**WELWYN HATFIELD BOROUGH COUNCIL
EXECUTIVE DIRECTOR - PLANNING, PUBLIC PROTECTION AND GOVERNANCE**

Application No: 6/2020/1177/FULL
Location: First and Second Floor 12 Harpsfield Broadway Hatfield AL10 9TF
Proposal: Retention of the use of the first and second floor levels from Retail (A1) to 2 small HMO units (with no more than four occupants each).
Officer: Ms Emily Stainer

Recommendation: Refused

Proposed - OS Map- Location

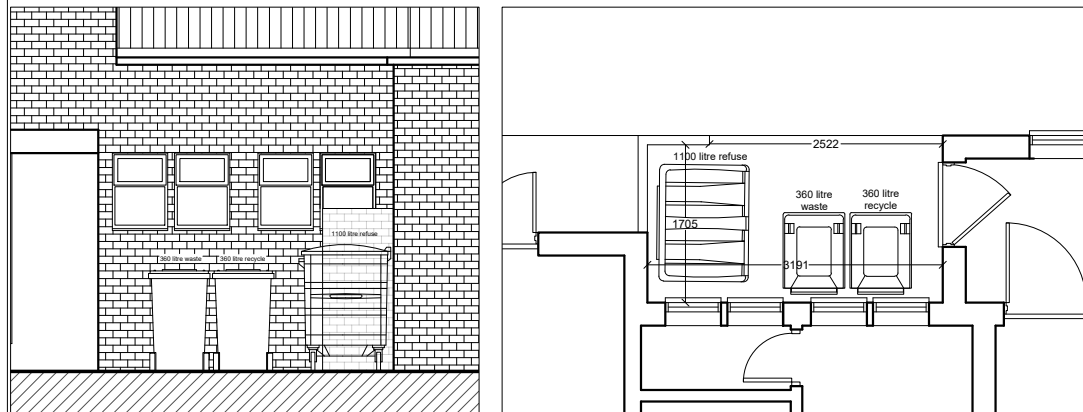
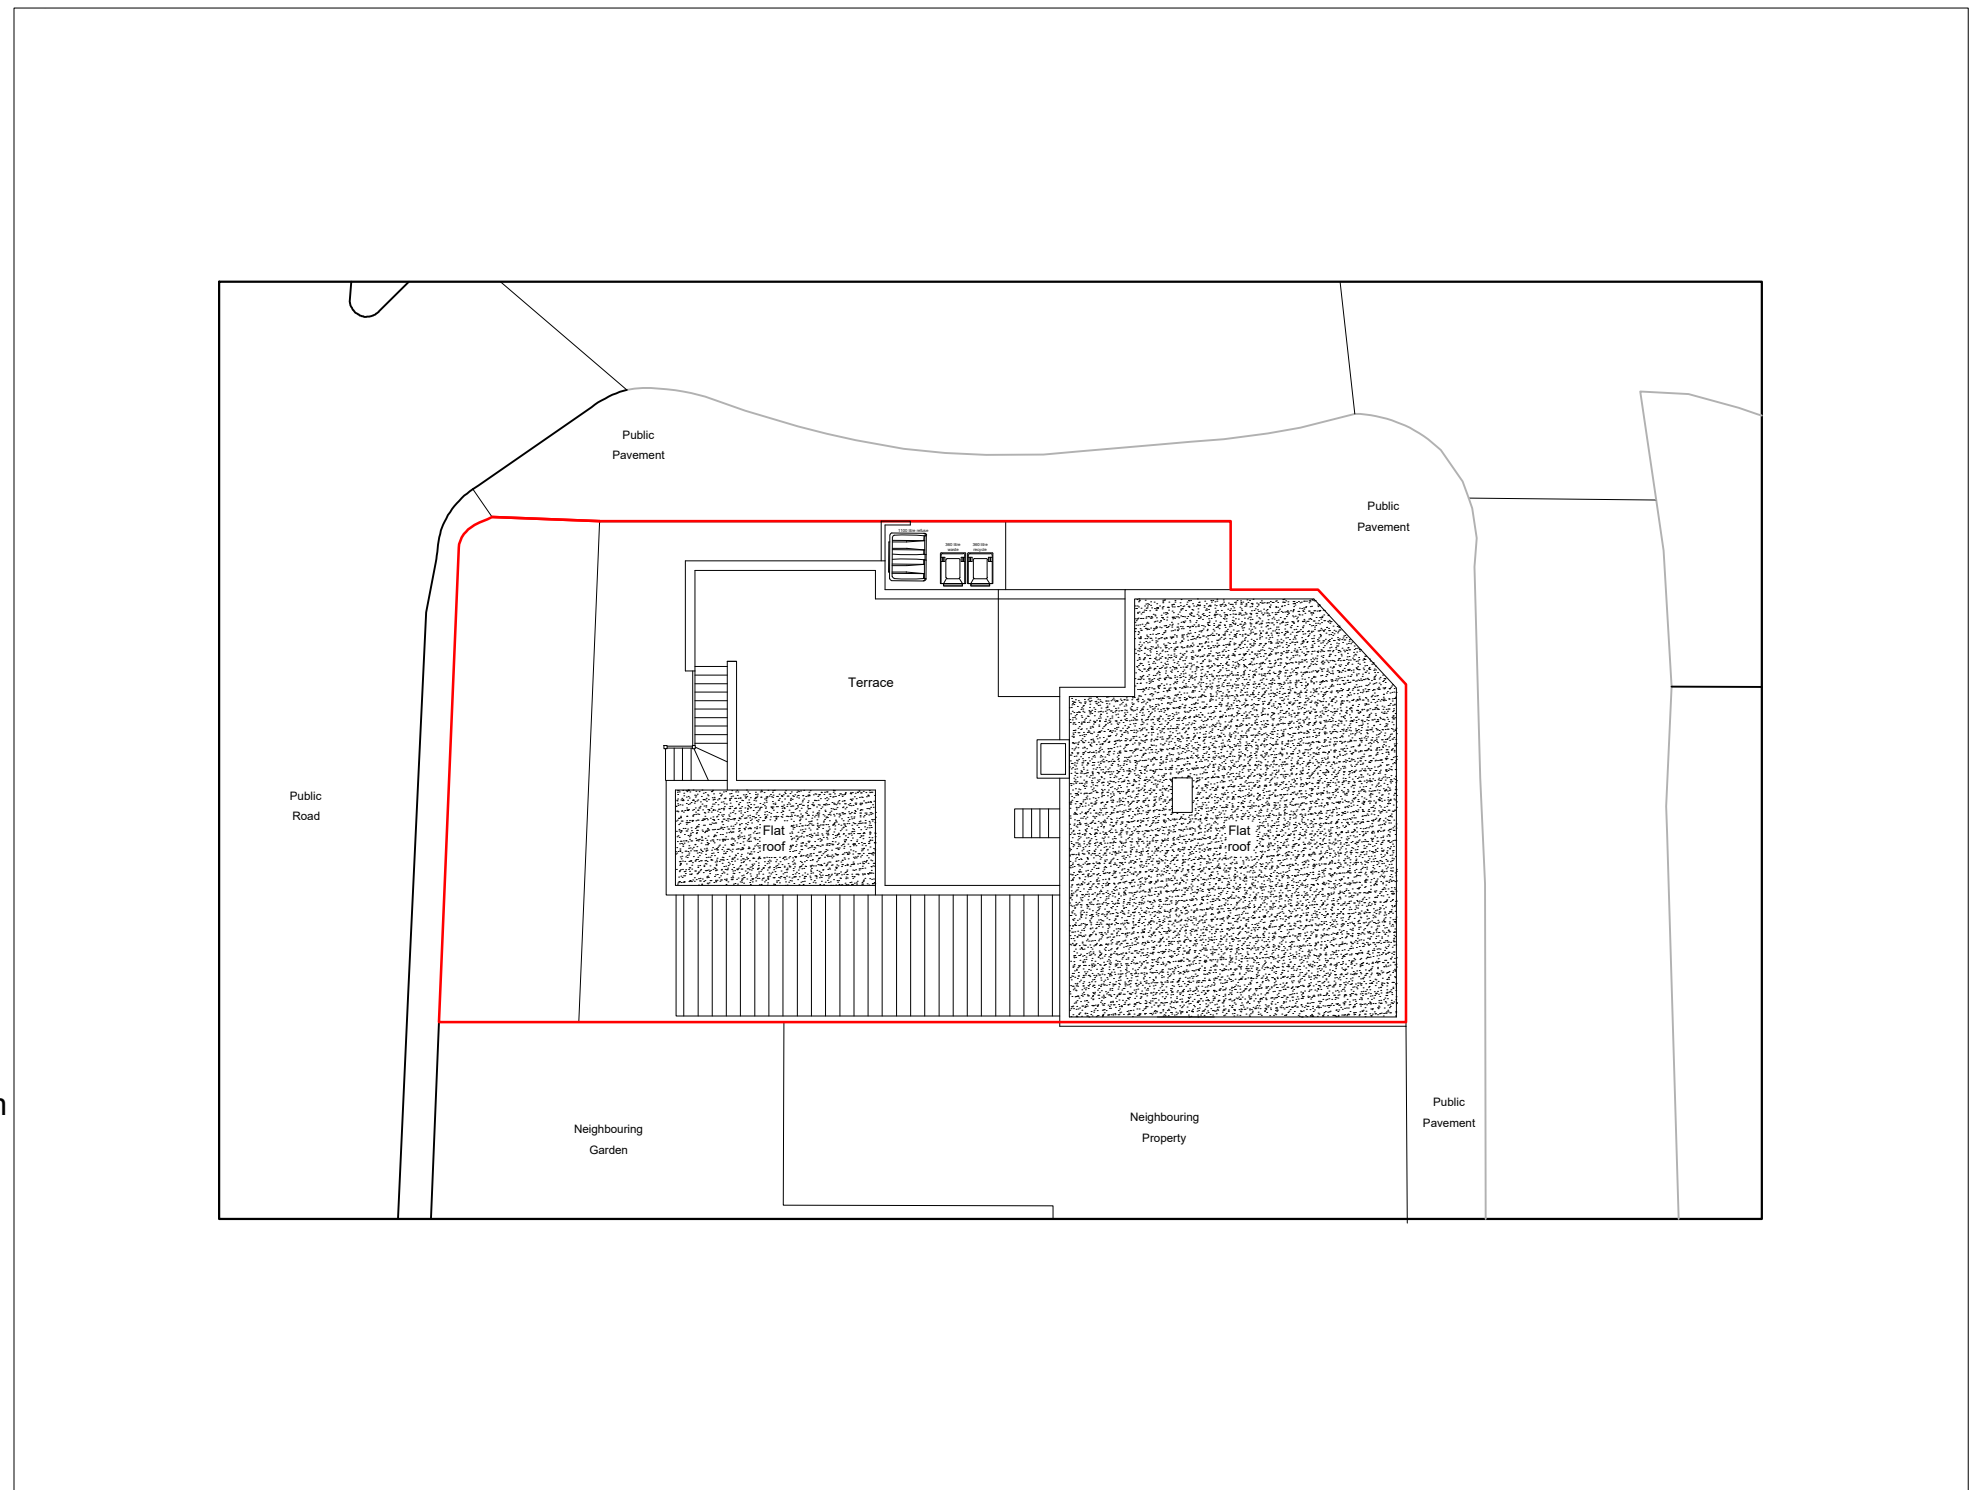
| <p>Any other considerations</p> | <p><u>Refuse/Recycling</u></p> <p>Criterion HMO4 of the HMO SPD requires the provision of an appropriate place for storage of waste and recycling bins. Client Services have confirmed that the properties could be incorporated into the existing scheme, however they expressed a concern regarding the proposed bin store. The bin store needs to have double doors opening outwards and be no more than a 15m drag distance from the store to the freighter. A dropped kerb would also be required at the point of pick up and a flat even surface to drag the bin. Whilst the existing brick wall separating the bins from the public footway is acceptable in amenity terms, this inhibits the occupants from accessing the bins externally. Limited information has been provided regarding access.</p> |

| | <p>Criterion HMO4 of the SPD outlines the capacity of bins required per occupant. Assuming the eight bedrooms shown on the floorplans are restricted to single occupancy only, the requirement for two, 4 person HMO's is 800 litres of waste to landfill bin capacity, 400 litres of recycling bin capacity and 400 litres of compost bin capacity. For the Council's residential refuse collection service to meet the required capacity the following bins would need to be provided. The proposed plans show one 1 x 1100L container and two 360L containers, one for waste and one for recycling. Client Services have confirmed that 1 x 1100L container and 1 x Mini Recycling Centre would be appropriate.</p> <p>Nonetheless, as outlined above, the plans show insufficient information regarding an appropriate bin storage arrangement. It is therefore considered that the proposal fails to comply with criterion HMO4 of the House in Multiple Occupation Supplementary Planning Document.</p> <p><u>Noise for Future Occupiers</u></p> <p>Policy R19 of the District Plan states that proposals will be refused if the development is likely to be affected by unacceptable noise or vibration from other land uses. This approach is reflected in Policy SADM18 of the Emerging Local Plan.</p> <p>The Council's Public Health & Protection Officer has been consulted for this application and considered that due to the level of traffic along Comet Way and noise associated with the restaurant and mixed uses below, the proposed development would be expected to require noise mitigation measures that ensure a suitable internal standard of amenity. In the event of permission being granted, a condition to this effect would be placed on the decision notice. A condition may also be required for mitigation measures for the plant equipment associated with the restaurant use on the ground floor.</p> |

4. Insufficient and inaccurate drawings have been submitted with the application to adequately assess the provision of car parking, cycle storage and bin storage against Policies GBSP2, D1, D2 and M14 of the Welwyn Hatfield District Plan 2005; Criterion HMO4 of the Houses in Multiple Occupation Supplementary Planning Document 2012; Supplementary Design Guidance 2005; Policy SP9 and SADM11 of the Welwyn Hatfield Borough Council Draft Local Plan 2016; and the National Planning Policy Framework.
